# Mallard Pass

### Applicant's Response to Deadline 7 Submissions

**Deadline 8 - October 2023**

EN010127/APP/9.47

Plate 7: Typical PV Array

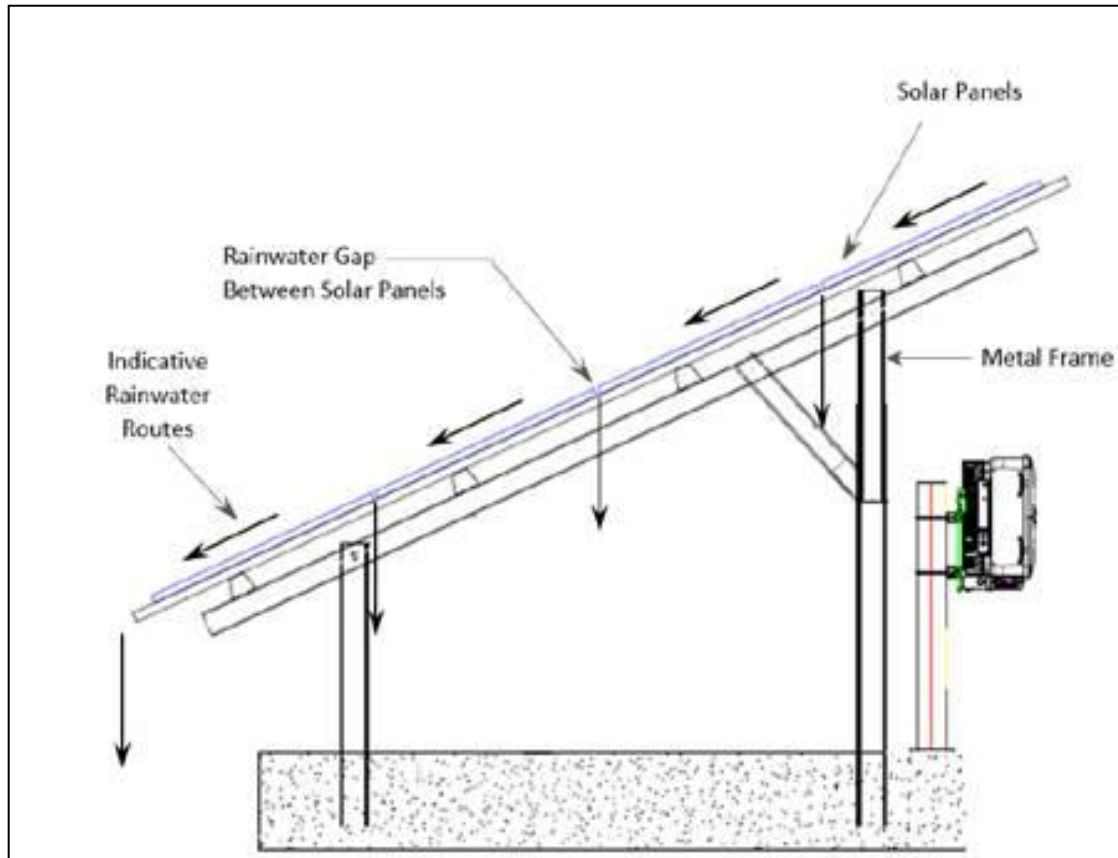
Parties Raised	Sub-Theme	Issues Raised	Applicant's Response
		<p>River in a short period of time, inevitably increasing river levels &amp; the risk of flooding in Greatford. But no, according to MP this can be reduced to a 0% increase by 4 measures;</p> <ul style="list-style-type: none"> <li>- As shown in plate 7 MP intends to leave gaps between the frame-mounted panels rather than a single drip line at the lowest end. Their reasoning seems to rely upon a report by Cooke &amp; McEwan which in summary, states ' solar panels do not have a significant effect on run off volumes or peak flows however where ground beneath panels is bare there may be an increase. MP, however make no reference to the conclusion in this report which states that in certain circumstances, the peak discharge could be in excess of 100%, which of course, would be a major problem!</li> <li>- MP are relying upon clay soils across the site not being compacted during the construction period &amp; that grass can be established both under &amp; between panels. This is referenced in Natural England's technical information note 101 which says ' the key to avoiding increased runoff &amp; soil into water courses is to maintain soil permeability &amp; vegetative cover. Permeable land surfaces underneath &amp; between panels should be able to absorb rainfall as long as they are not compacted &amp; there is vegetation to bind the soil surface.</li> </ul>	<p>It should be noted that the Applicant has updated Appendix 5.1 (submitted at Deadline 5) to include a parameter that limits the surface area of panels to 1,647,300 m<sup>2</sup>. Based on the confirmed PV area, the theoretical surface water increase (assuming PVs on the ground rather than on a racking system) would be a 90 %. Therefore, the calculations presented in Table 7 of Section 3.1 of Appendix 11.6 are an extremely conservative scenario.</p> <p>The raised nature of PV Arrays will not prevent soil from absorbing rainwater as the panels will not be placed directly on the ground and each PV Row will be separated, with the same area of soil available for infiltration as per the baseline scenario. Therefore, the calculated increase does not represent the impact of the PV Arrays on surface water runoff.</p> <p>The Applicant has explained how the Proposed Development is likely to lead to reduced surface water run-off rates compared to the baseline agricultural scenario in its answer to Q12.0.6 a) in the Applicant's Responses to ExA's First Written Questions [<b>REP2-037</b>], principally through the implementation of advanced sowing of grass, where appropriate, in addition to planting and vegetation. This approach has been utilised on other solar developments of similar scale and the methodology has been reviewed by the relevant regulatory bodies.</p> <p>The conclusion of the Cook &amp; McCuen study states that "<i>when gravel or pavement was placed under the panels, with the spacer section left as patchy grass or bare ground, the volume of the runoff increased</i></p>
